Response to consultee comments in blue:

West Sussex Landscape	
Require the following information and modifications: (1) South of the Main Avenue should have a continuous verge (better for tree establishment / long term survival than individual planting locations). Buildings need to be set back from the footway edge to give good separation between the building elevation from trees. Continuous verge also removes the need for granite sett edging and tree grills which will require maintenance and may become distorted. (2) For any remaining tree pits section / plan drawings are required. Stakes / ties are also indicated instead of ground anchors which is unusual. (3) Services to be located in footway / carriageway not verges. (4) Error on the outline specification on LA101: subsoil British Standard is BS8601:2013. (5) Reconsider use of hornbeam, with other suitable species.	(1) The majority of south of the Main Avenue abuts the retail element that will be delivered as part of a separate RMA. It is considered that a continuous verge would not be appropriate as this area will form part of the public realm that will be developed as part of the retail RMA. As detailed in the Development Fr

General tree pit detail
Scale 1:10

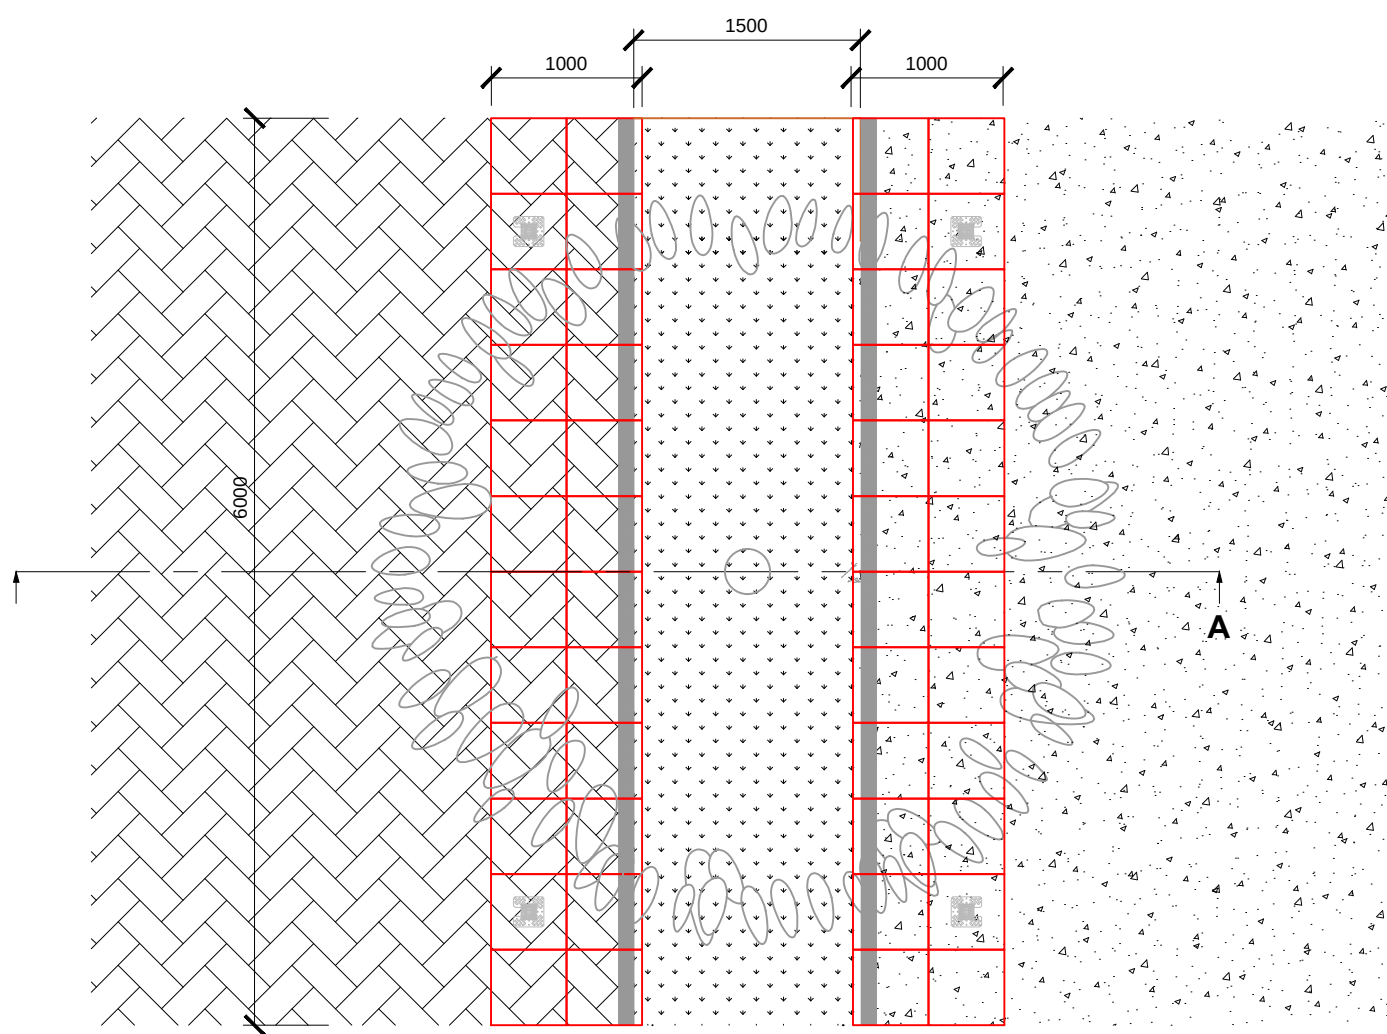
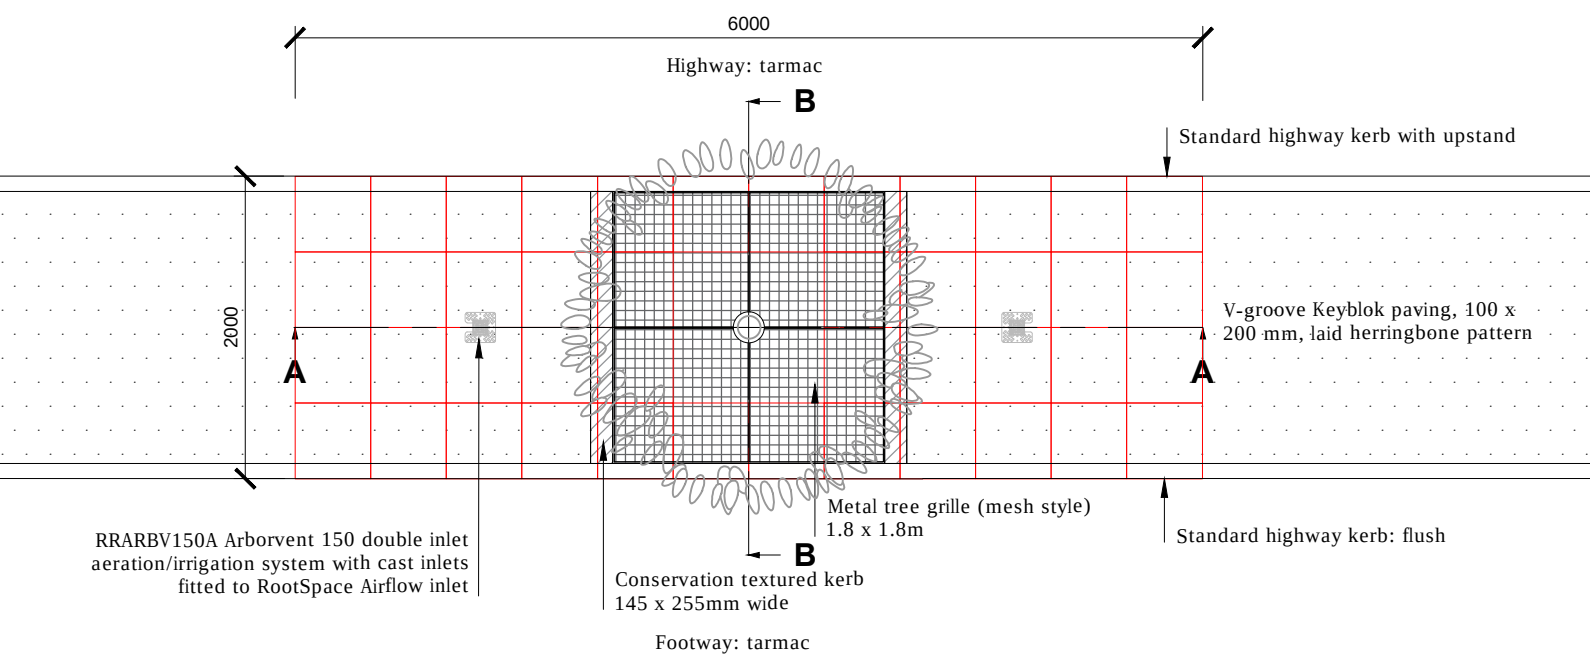
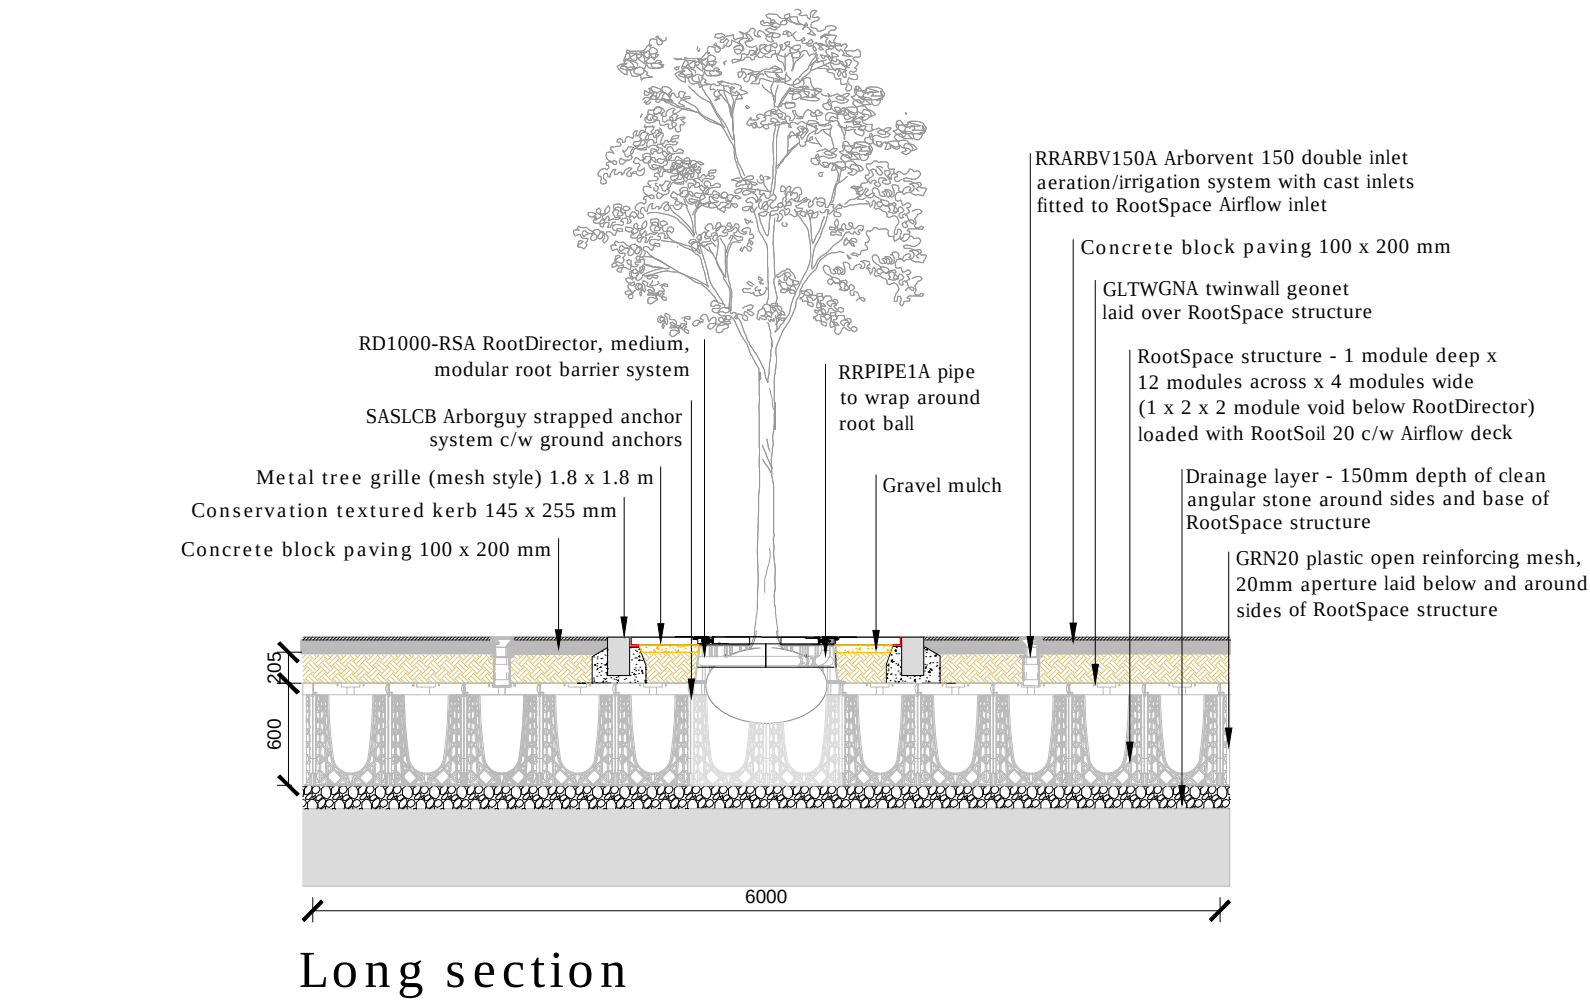
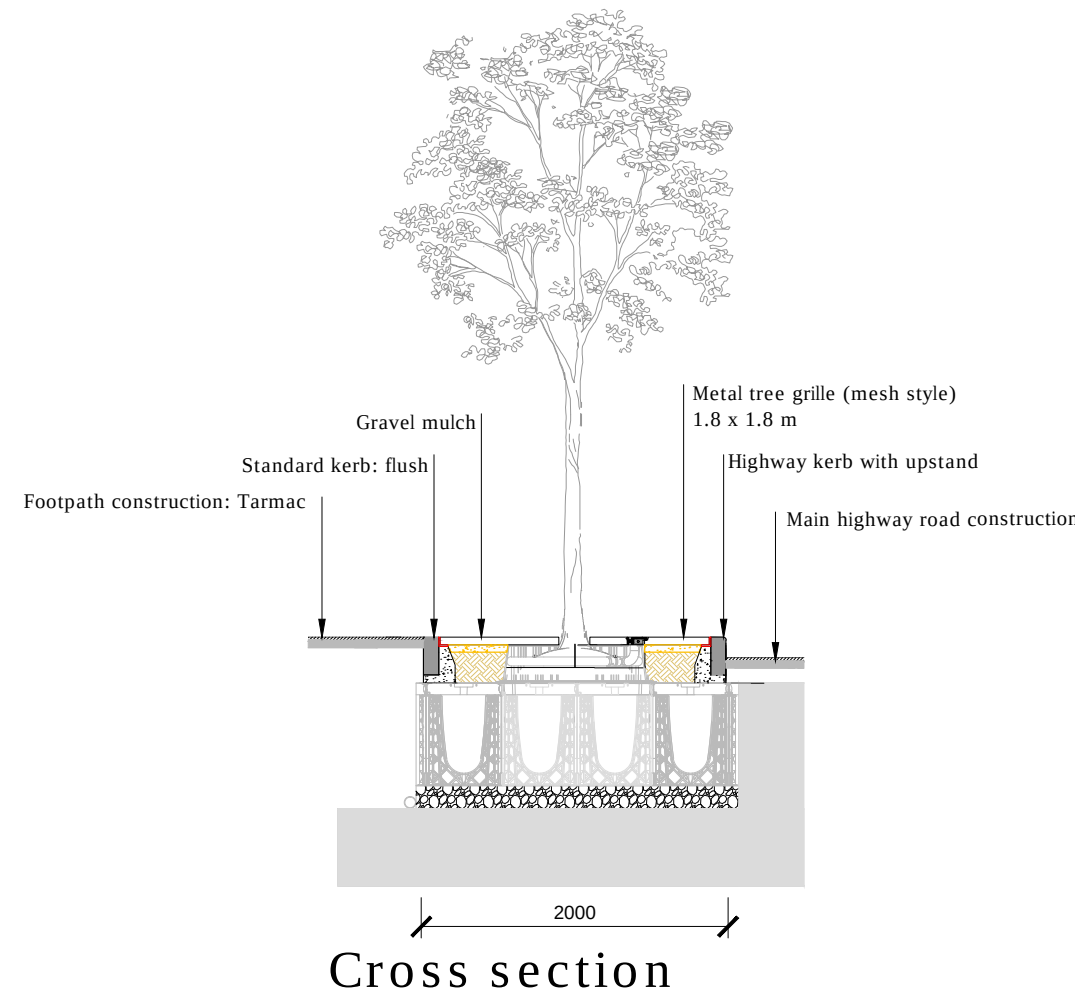
(1) Also require a review of tree species choice and form in accordance with West Sussex Landscape. Frax Frax would be a welcome species choice in this area. (2) Planting pit formation cross section and specification required. (3) Confirmation of who will be responsible for maintenance. (4) Clarification if LEAP is to be fenced / gated area or play	(1) Noted. (2) Noted refer to drawing LA108. (3) The management company that has been established for the site. (4) Noted– suggest fenced. Landscape drawings have been amended accordingly.
West Sussex Highways	
Require the following information and modifications: (1) An RSA and Designers Response is required. (2) Tracking diagrams of Main Avenue (bends and / or curves) required (3) Tracking of refuse and fire vehicles to Plots 95-100 and 117-122 shows overriding of access points to the main carriageway and over-sailing of the footway opposite. Or else consider bin stores located within suitable distance to the main access roads. (4) The raised table adjacent to plot 95-100 should be reviewed as the surface treatment is not consistent with the other tables elsewhere. (5) Layout differences with s73 Master Plan need explaining.	(1) A Stage 1 RSA and associated Designer's Response Report was provided with the original submission. This has been updated to account for the amended layout. (2) The anticipated vehicle swept paths of a large refuse vehicle and large car are indicated on drawings numbered A/PHLITTLE-INT.1/TK-1 and 2. (3) Plots 95-100 – A bin collection area is located just inside the parking area which would allow the refuse vehicle to wait on Road Three to collect bins thus avoiding the need to turn within the car parking area. Plots 117-122 – A bin collection area has been added adjacent to Road Two allowing the refuse vehicle to wait on Road Two and thus removing the requirement for the refuse vehicle to turn within the parking area. (4) Bitumen surfaced raised tables are proposed on the Main Avenue because the Main Avenue is to become a bus route and Bitumen is considered a more durable surface material for such locations. (5) The layout has been reviewed to accommodate all comments raised. The parameter plans submitted with the s73 application form the base of the detailed development proposed through this RMA
